From: Laura Gibbons <Laura.Gibbons@arun.gov.uk>
Sent: 08 June 2021 12:32
To: Planning.Responses <Planning.Responses@arun.gov.uk>
Cc: Michael Eastham <Michael.Eastham@arun.gov.uk>
Subject: A/84/21/DOC

We have the following further comments on this discharge of conditions application.

Condition 23 SuDS details

Condition 28- surface water drainage strategy

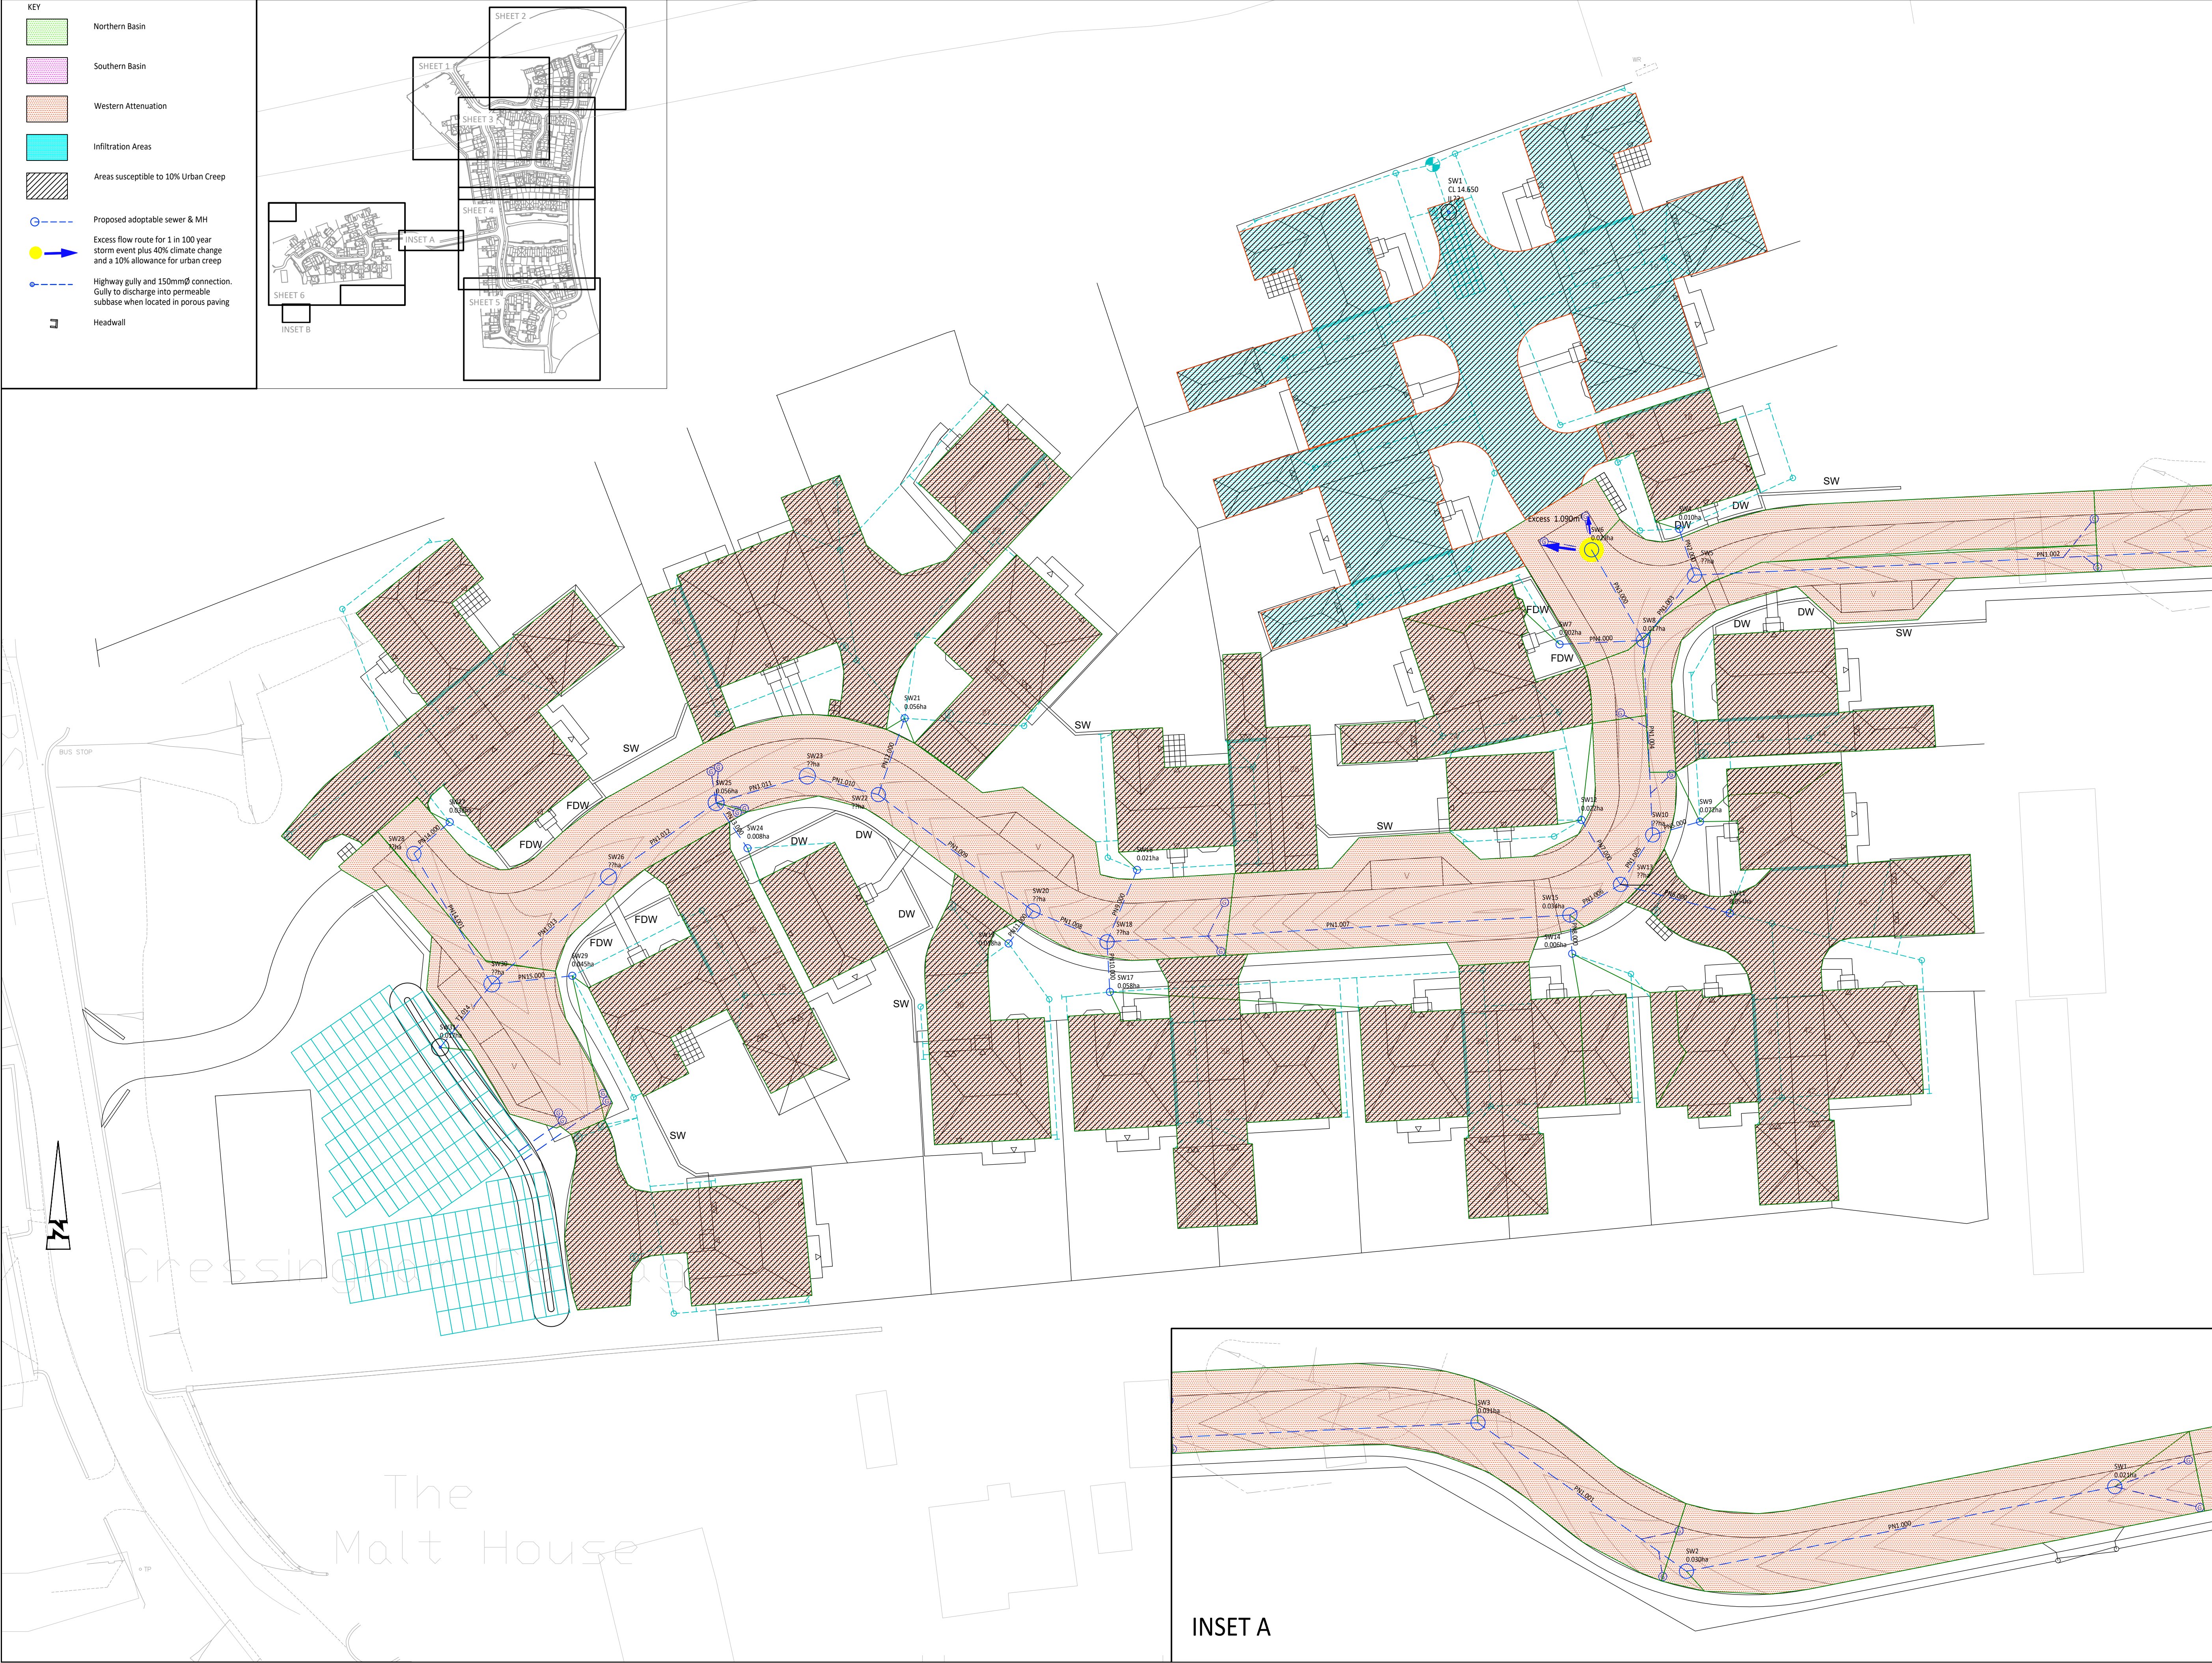
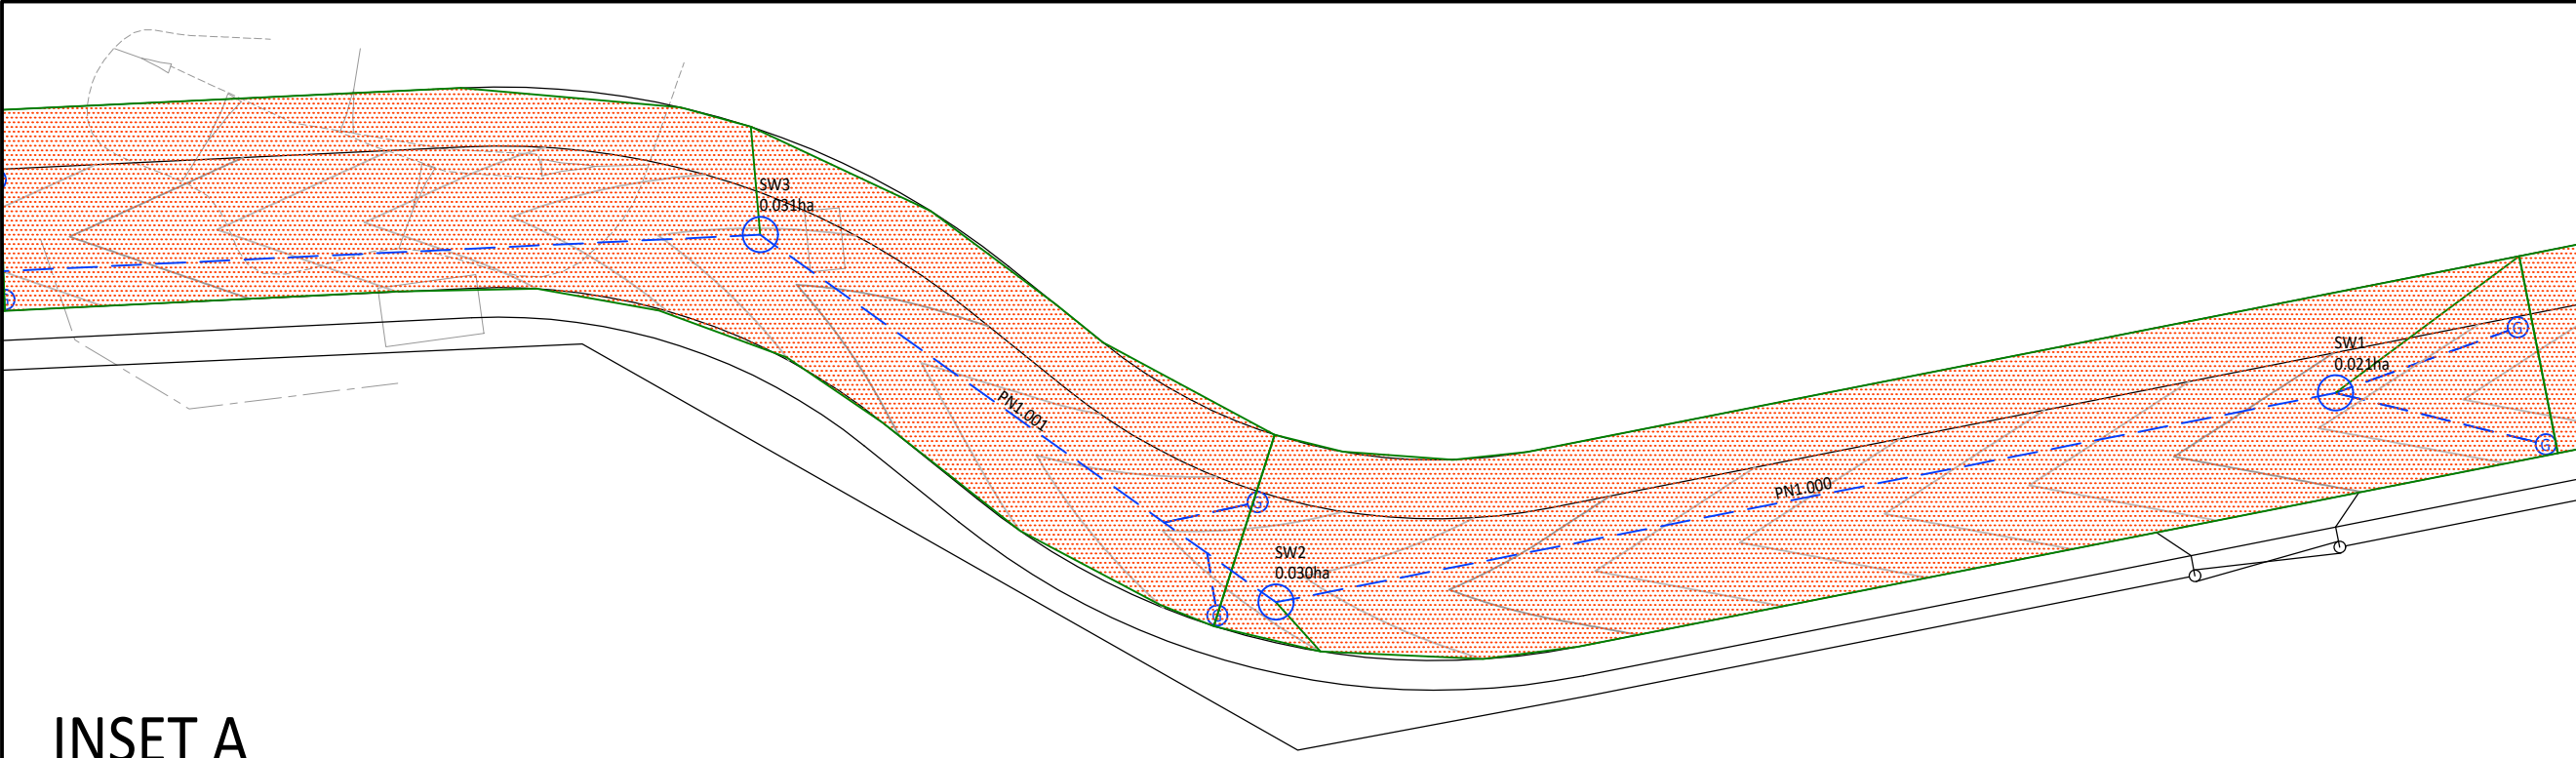
Please make it clear on impermeable areas plans and calculations where urban creep is added. The results provided show impermeable areas plans for the southern catchment matching those in the first set of

calculations in the previous printout, which according to your above statement did not include urban creep.

Aquacell Core Soakaway
Base layer 90.2m² x 0.4m deep
2nd layer 57.4m² x 0.4m deep
Base Invert Level: 12.90
Incoming Pipe invert 13.30
Volume of storage based on infiltration rate of
4.857 x 10⁻⁵ m/s

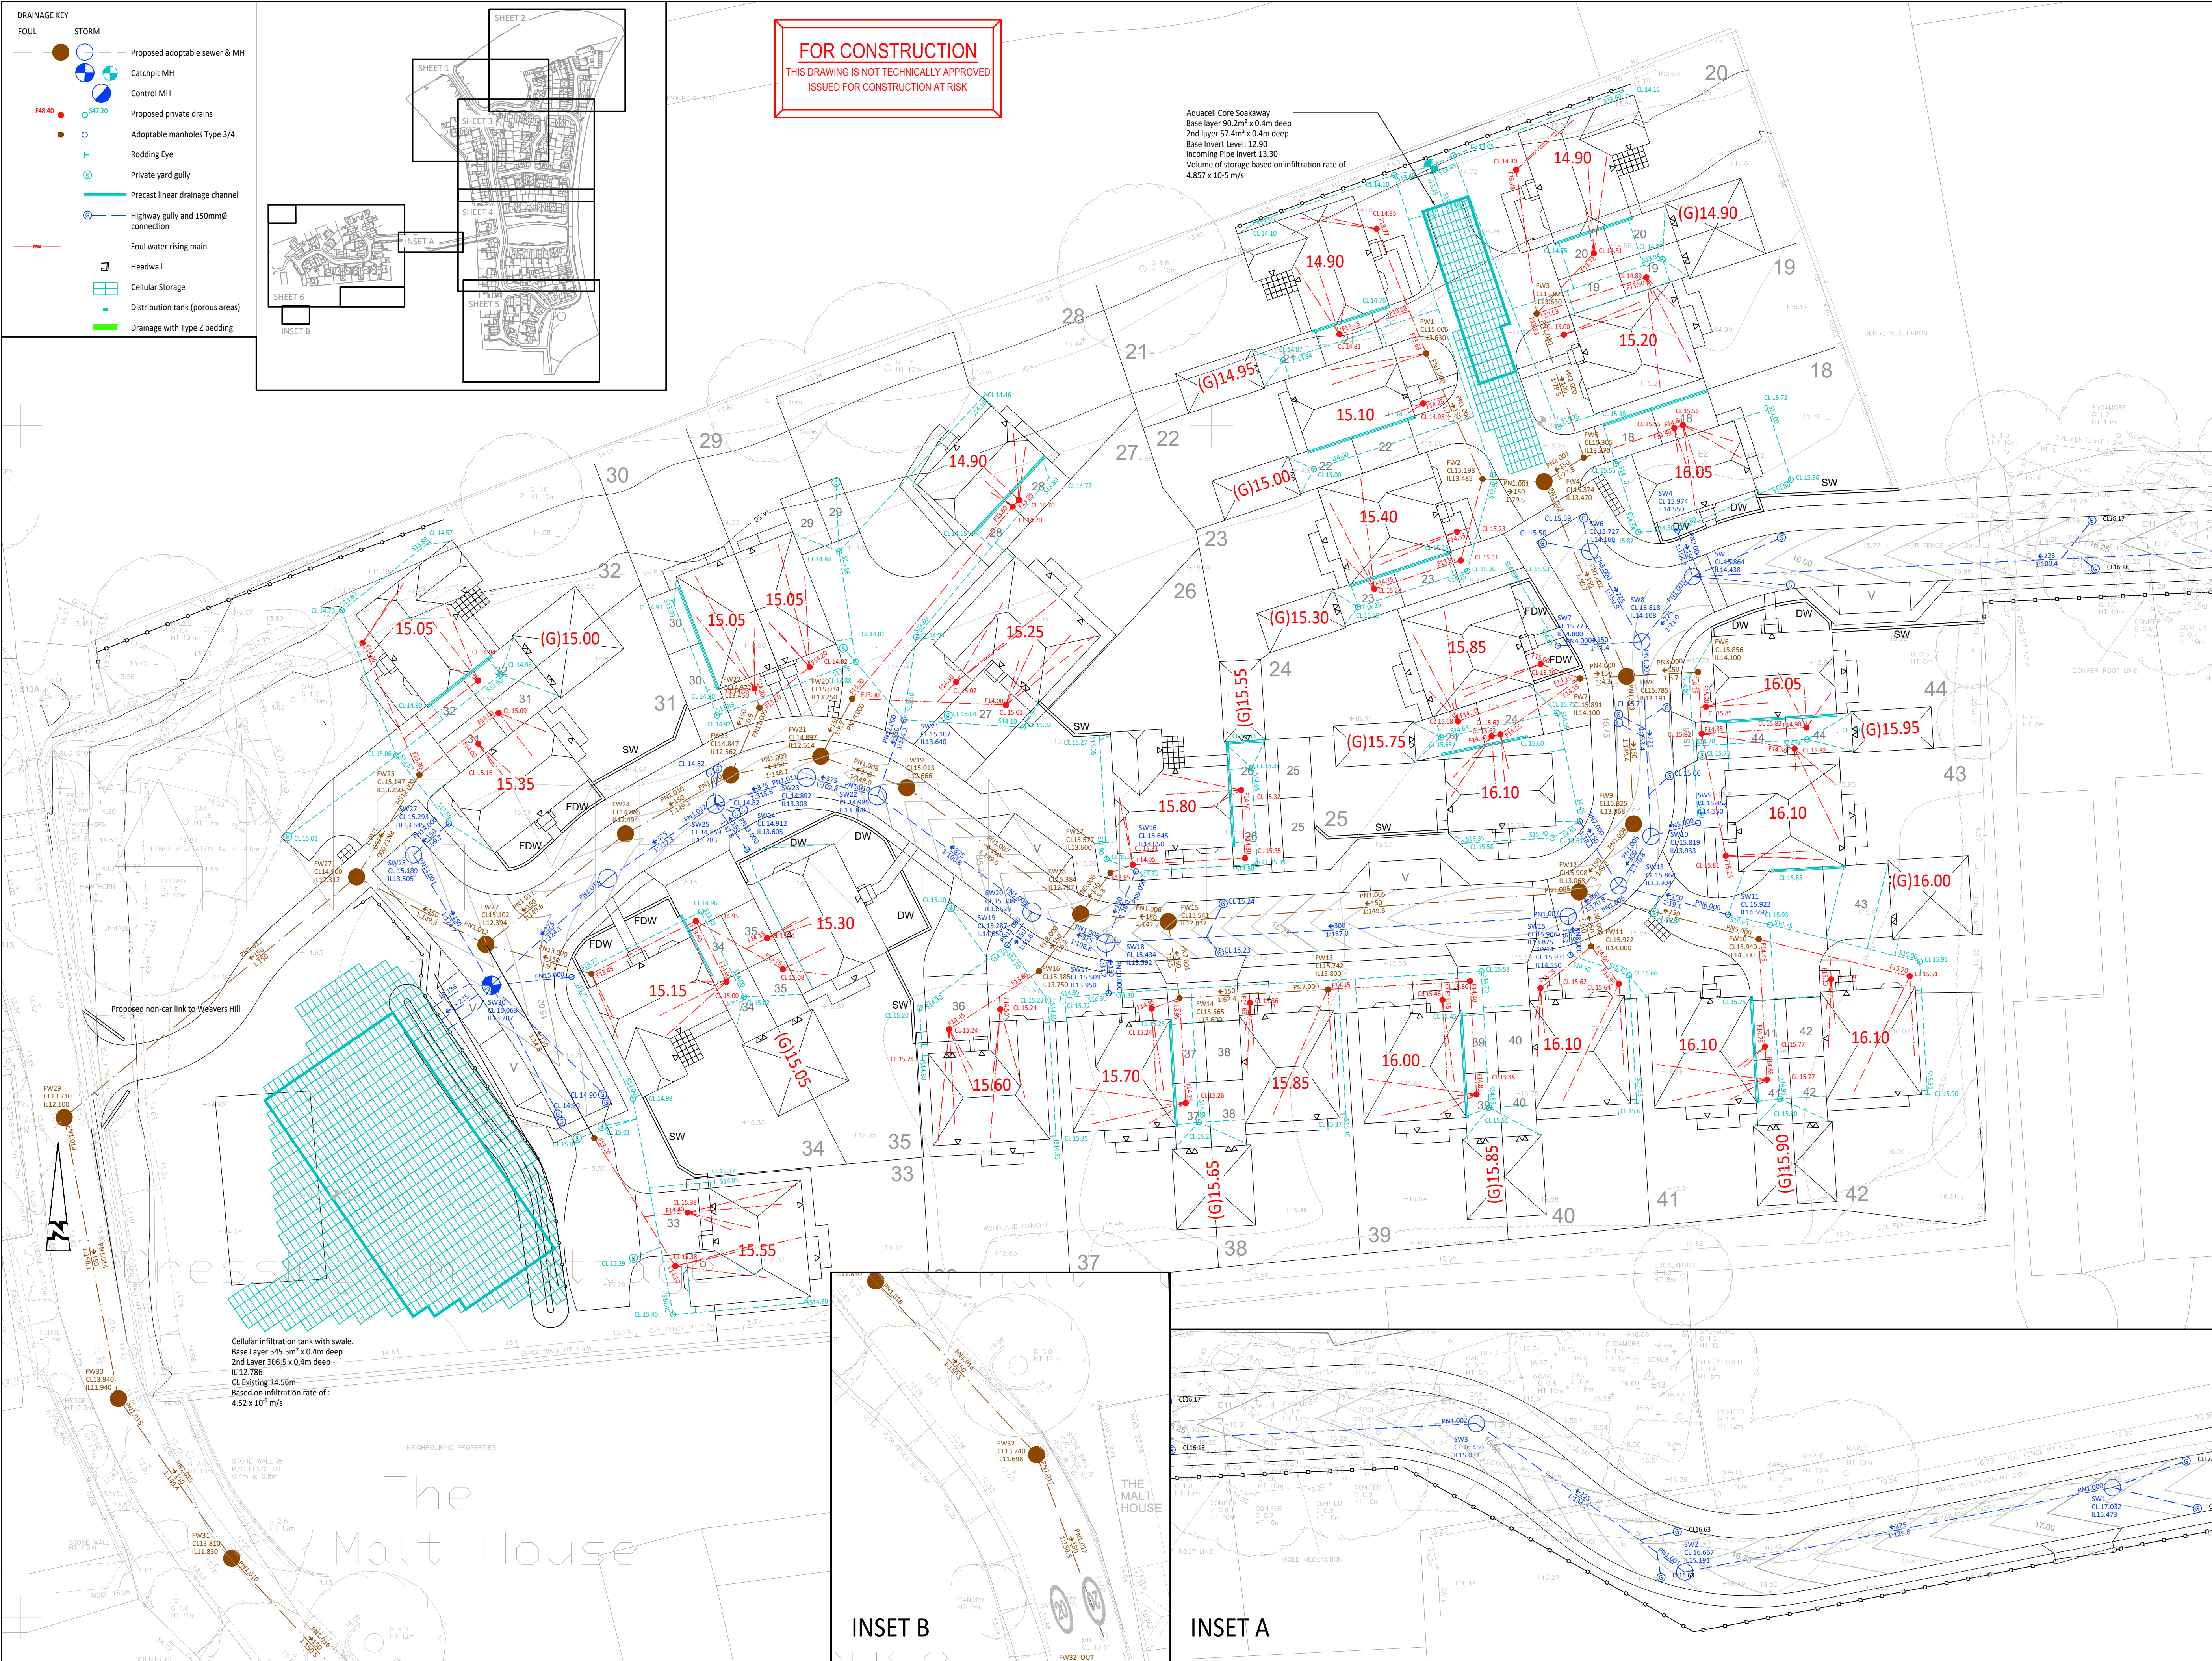
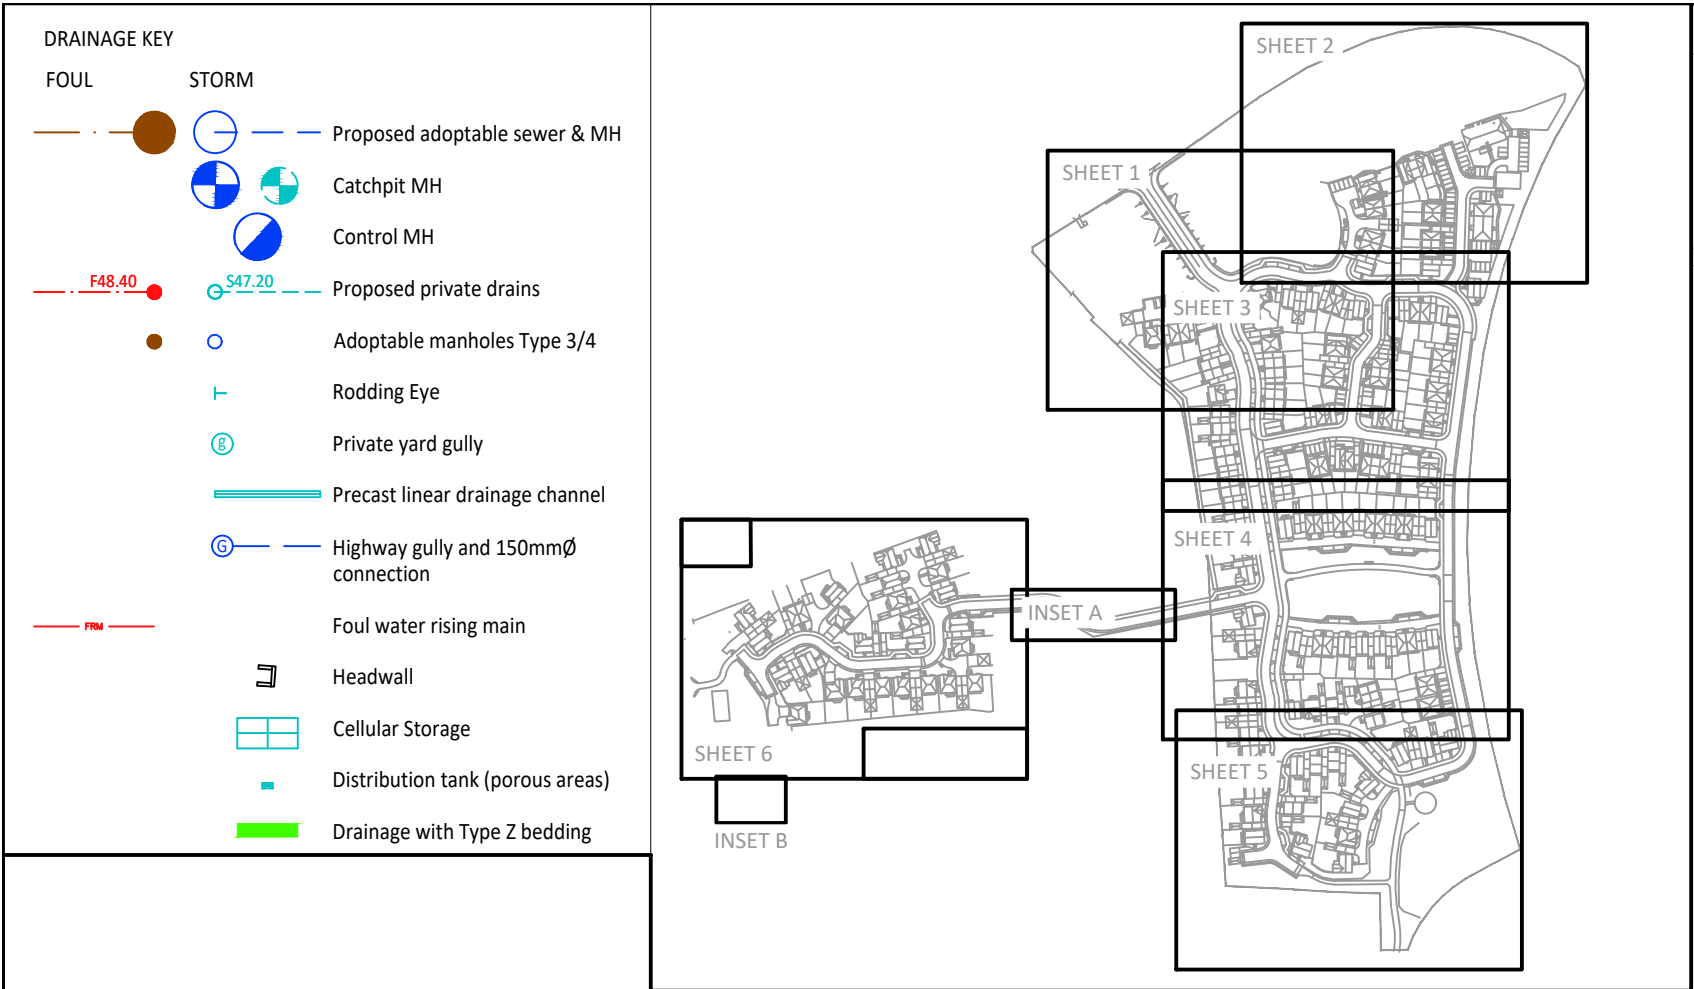
This has been noted and included on the drawings. *This is still incorrectly detailed. This has been noted and included on the drawings. Okay, will be reviewed once appropriate calculations are supplied. Cover level of the main western infiltration crate is inconsistent between layout and detail drawing.*

The swale is still not included within calculations. The area of the 2nd layer of crates is modelled as 355m², yet only 195.5m² is modelled on plan. Please ensure consistency.
